Application No: CM/70/21/PL
Site Address: Land at Wren Cottage Horsemere Green Lane Climping BN17 5QZ
Description of works: Subdivision of the plot and construction of 3 detached bungalows with associated parking, access and landscaping (resubmission of CM/17/21/PL). This application is in CIL Zone 3 and is CIL Liable as new dwellings.

Thank you for your internet representation made on 8th December 2021 which has been recorded as an objection with the comments as follows:

Title
Location & Block Plan

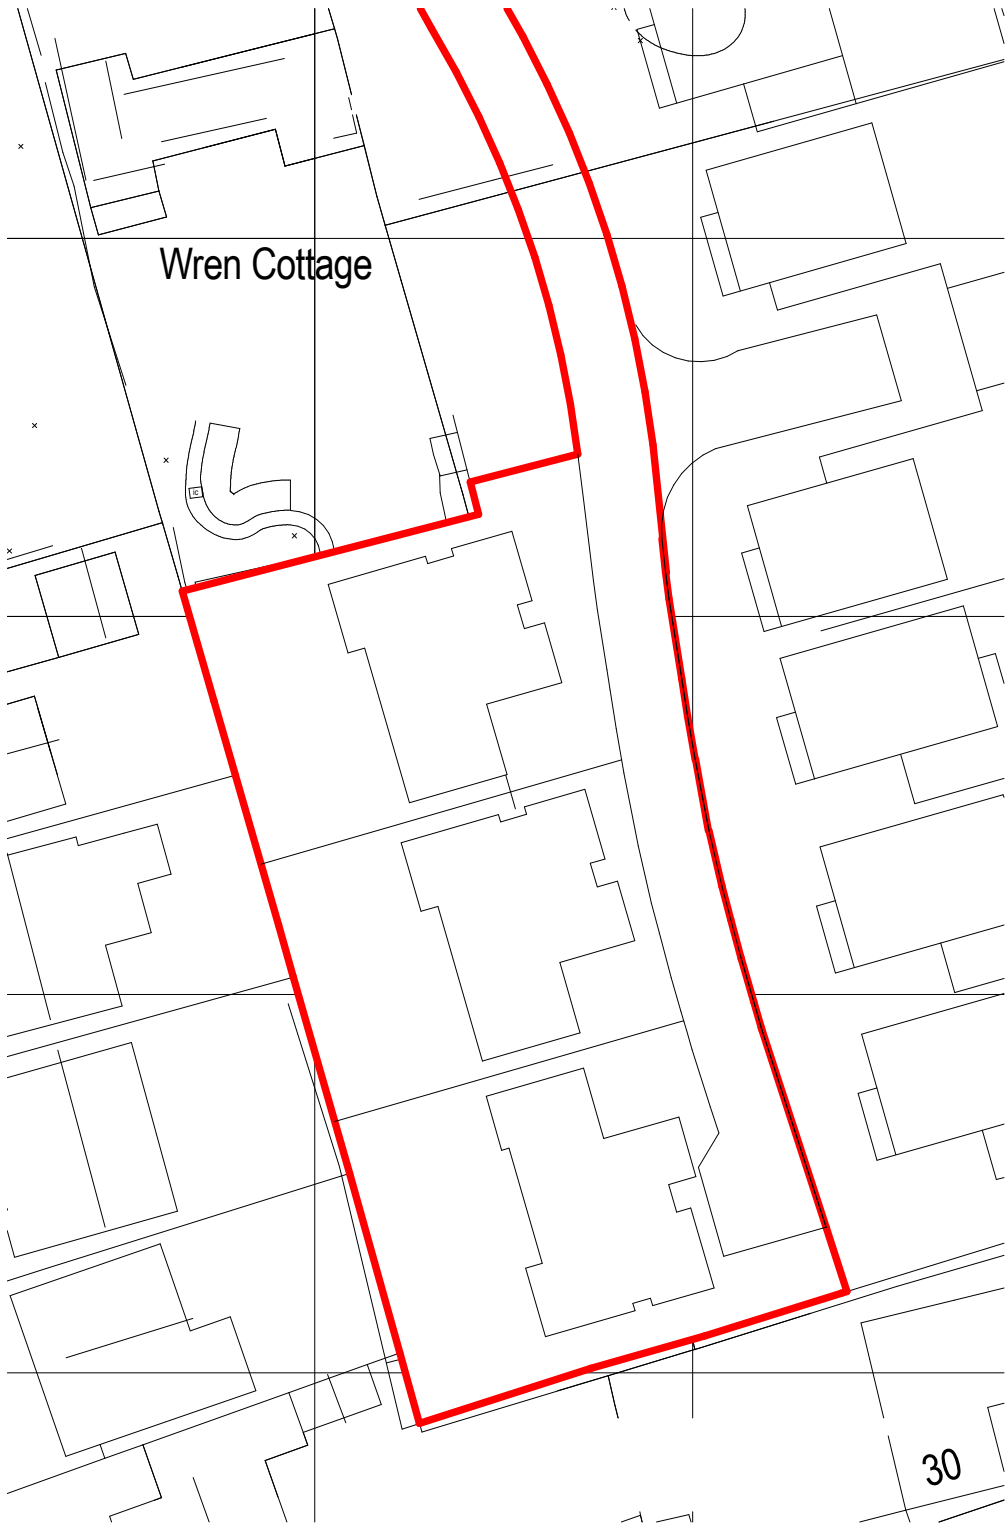
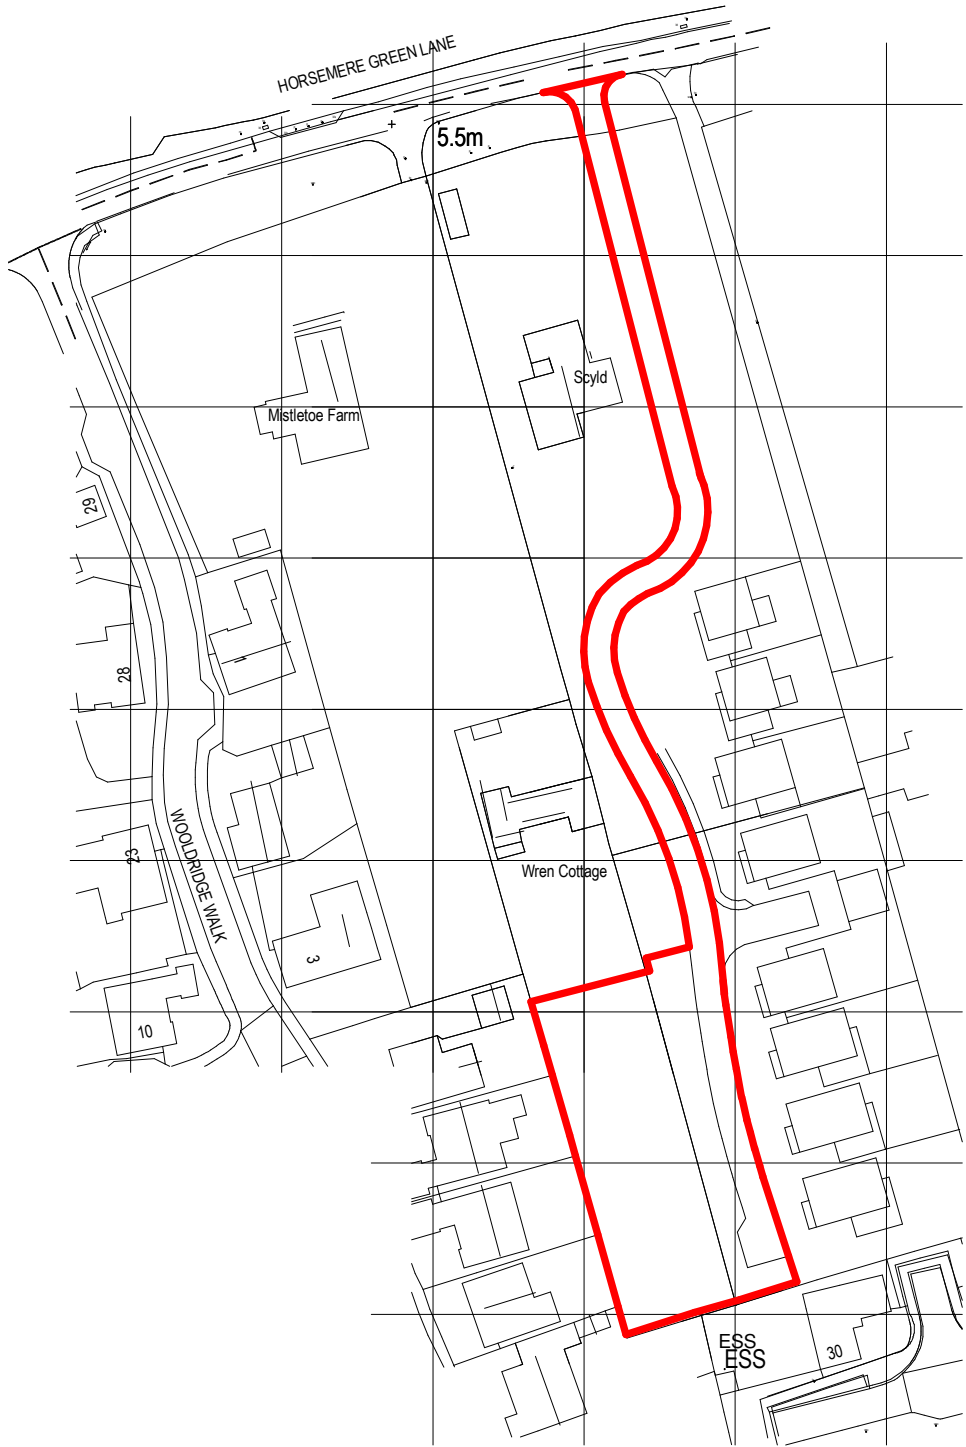
On looking at these revised plans it seems clear that the planned area for this development has not changed from the previous plans except that they have been changed from two storey dwellings to single storey dwellings bearing in mind that a three bedroom bungalow will require a greater minimum garden size (about 60-70 sq ft) to accommodate 3 bedrooms.

Therefore in my view as the proposed plans stand, the back to back proposed plan would not ensure standard requirements

for the development or a layout and design that provides standards of privacy and outlook for both existing and proposed residents. Our previous discussions on site with Neil Crowther (prior to planning refusal) he confirmed that the size of the proposed plots did not meet the standard building requirements and feel these have not changed therefore 2 bedroom dwellings rather than 3 bedroom would be more in keeping with the plot size.

We probably will lose the privacy of our garden space and any outside activities in our garden might be under threat by inadequate garden space by a proposed cramped back to back development. Also I would like to mention that any potential extension or any outbuilding (for example garden office or conservatory) if considered would bring the whole development even closer to my property.
